**PAVEMENT DESIGN REPORT
RETREAT AT TIMBERRIDGE Filing No. 3
EL PASO COUNTY, COLORADO**

PCD File No. SF2241

August 16, 2024

**TABLE B-2  
SUMMARY OF CTS TEST RESULTS**

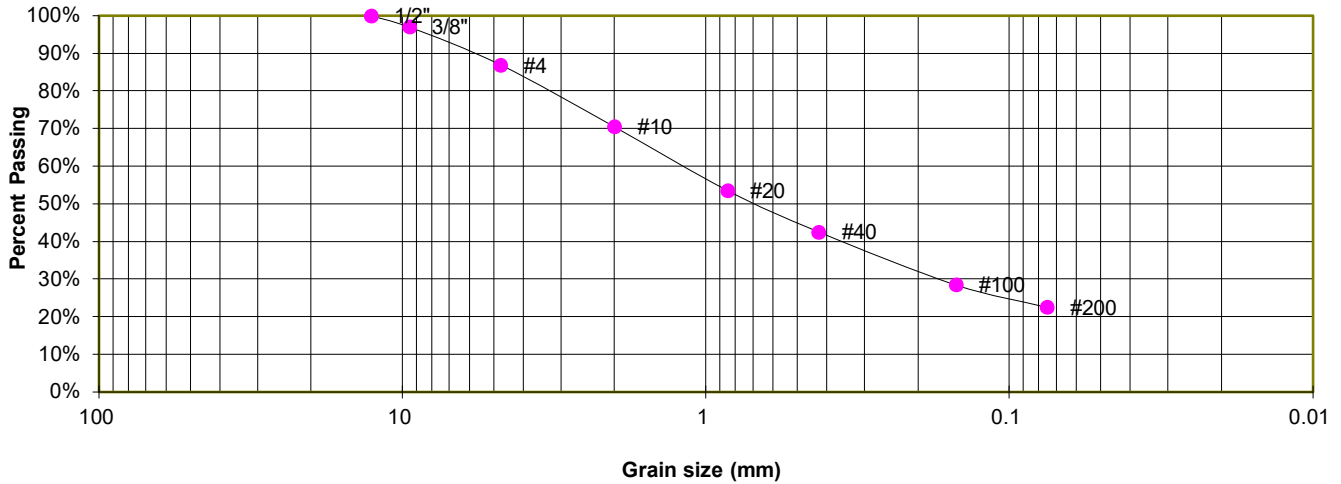
note 3 of table D-3 indicates strength greater than 275 psi shall require micro fracture. this section should also include what the strength of the CTS should achieve at the 7 day period based on the SN number used to calculate.
